EPC STORMWATER REVIEW COMMENTS ARE SHOWN IN ORANGE BOXES WITH BLACK TEXT

GRADING & EROSION CONTROL (GEC) PLAN SHEET INDEX

INTELIFAB LOT 1, MAYBERRY, COLORADO SPRINGS, FIL. NO. 2

SITE GRADING & EROSION CONTROL PLAN

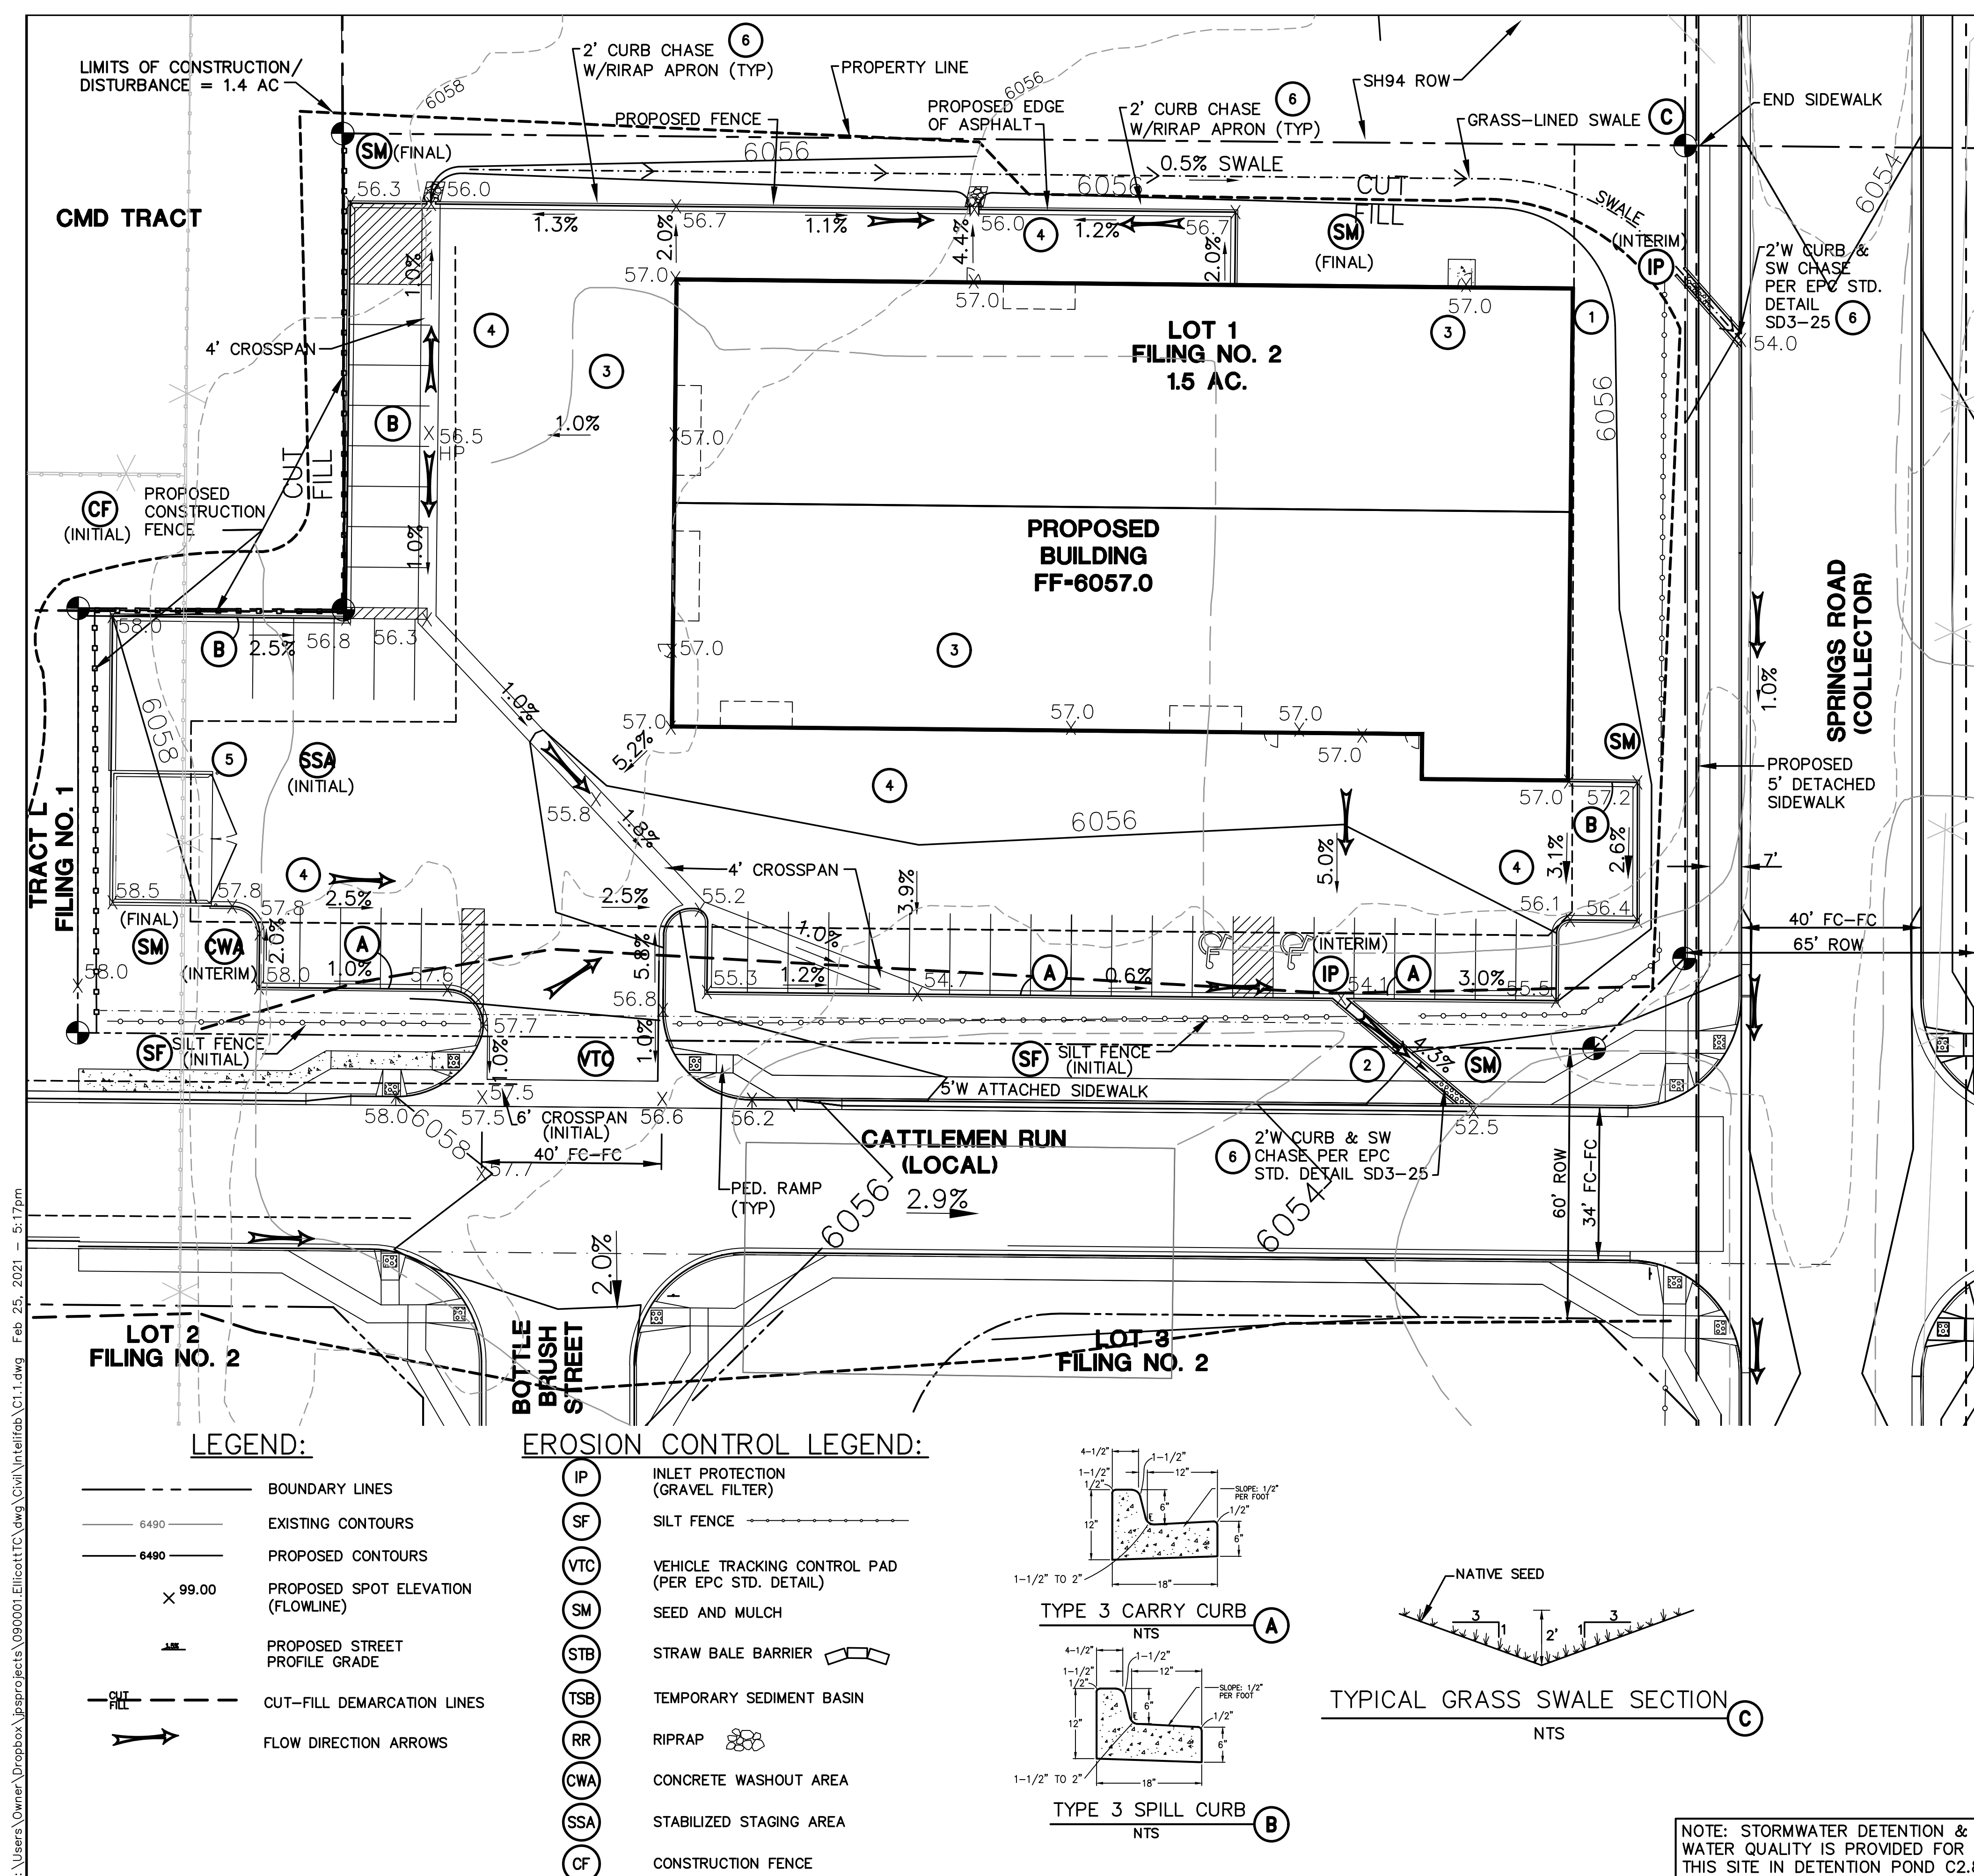
Show vicinity map with pond from Filing 1 to show where the stormwater runoff will be treated.
 Unresolved.

Label all proposed temporary construction control measures by phase of implementation (initial, interim, final).
 Unresolved.

The figure needs to show Property Boundary, Limits of Disturbance and Construction Boundary.
 Unresolved.
